Ref: 6/2019/0218/LB & 6/2019/0217/MAJ
Date: 28/05/2019

HISTORIC BUILDINGS AND CONSERVATION ADVICE

RE: *Northaw House, Coopers Lane, Northaw, Potters Bar, EN6 4NG*

PROPOSED NORTH ELEVATION, STABLE BLOCK
1:200

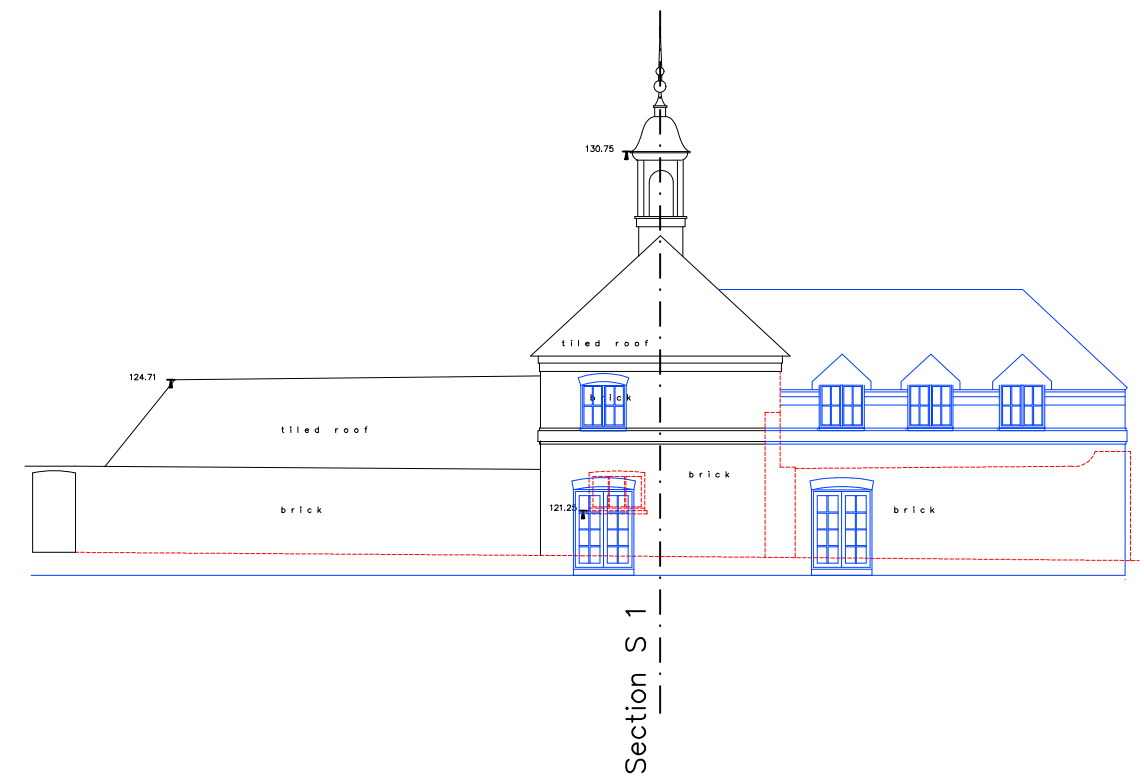
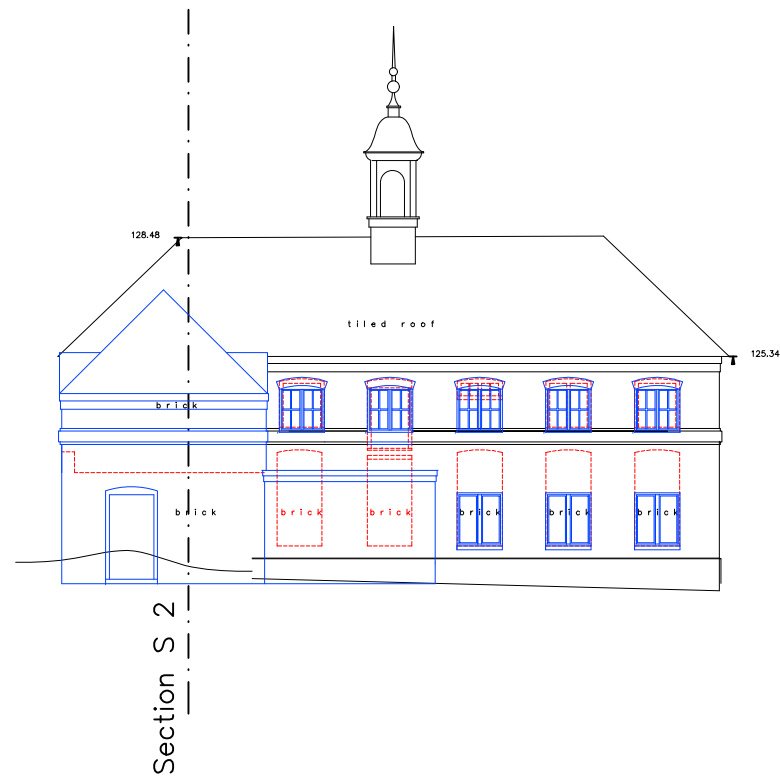
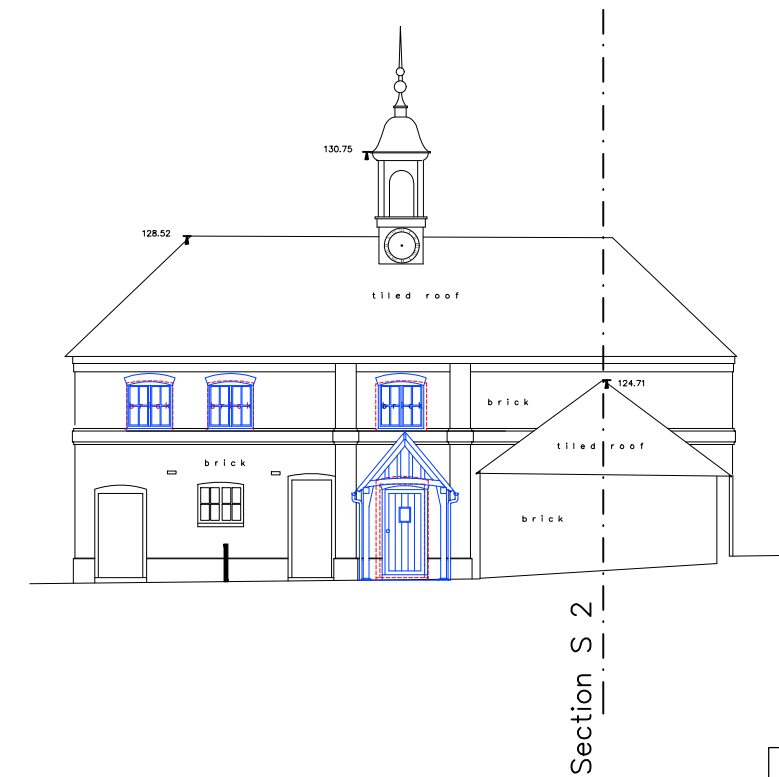
The proposed conversion and extension to the stable block raises no objections. The design of the extension has been revised following a site meeting to omit the dormer windows by heightening the eaves level. The extension is detailed to match the existing building but with a lower ridge height to provide some distinction between the original block and the new extension. Internal access into the building was limited due to its poor condition and structural concerns and so the survival and potential for the retention of internal finishes, fixtures and fittings is unknown. The retention and reuse of these can be reserved by condition.

- Additional drawings that show details of the junction between the new extension and the existing building shall be submitted to and approved by the Local Planning Authority in writing prior to the construction of the extension.

- [In addition to the general condition regarding external materials above] A sample panel of brickwork, minimum size 900 x 900 mm, to show the brick, bond, mortar mix and pointing profile of the new extension, shall be built on site prior to the commencement of the building of the new extension and shall be approved in writing by the Local Planning Authority, and the development shall be carried out in accordance with the approved plans.

PROPOSED WEST ELEVATION, BALLROOM WING

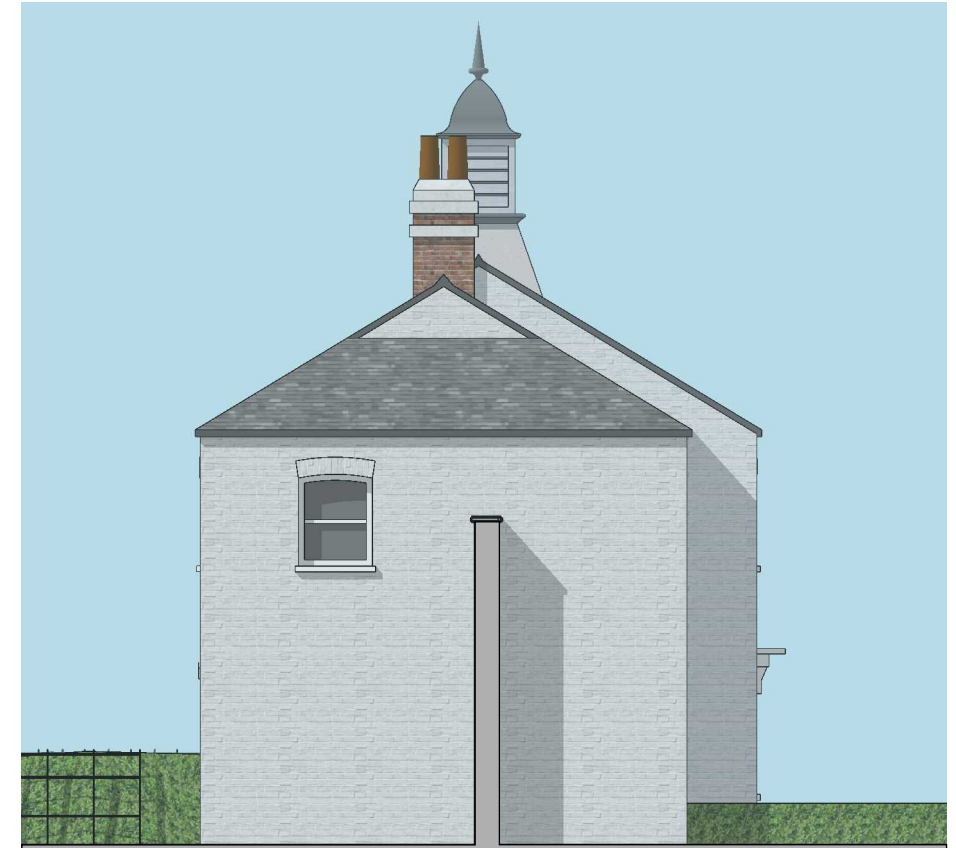
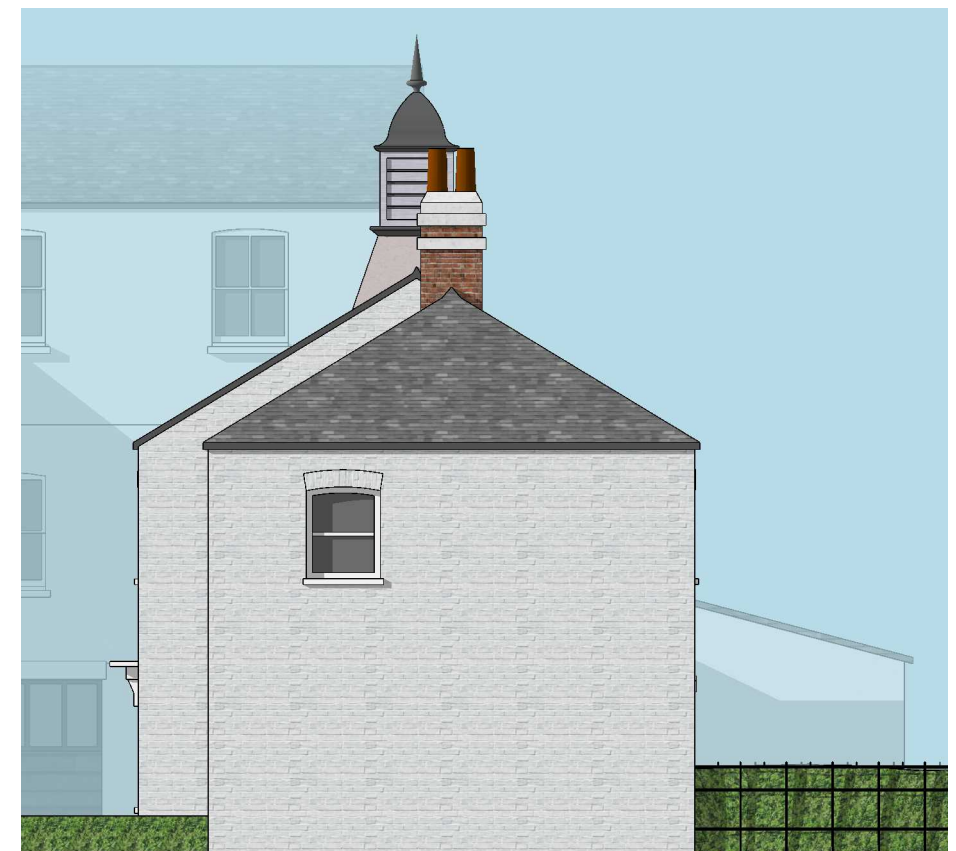
The proposed conversion scheme for Northaw House and the Ballroom Wing raises no objections. The proposed floorplans have been amended following meetings on site and see the retention of more historic fabric and greater legibility of the historic layout than the previous floorplans. The scheme largely follows existing divides and circulation spaces within the building and avoids the division of principal rooms. The demolition of the poorly constructed corridor extension to the Ballroom Wing and the single storey additions to the west are uncontentious and beneficial in improving the appearance of the house.
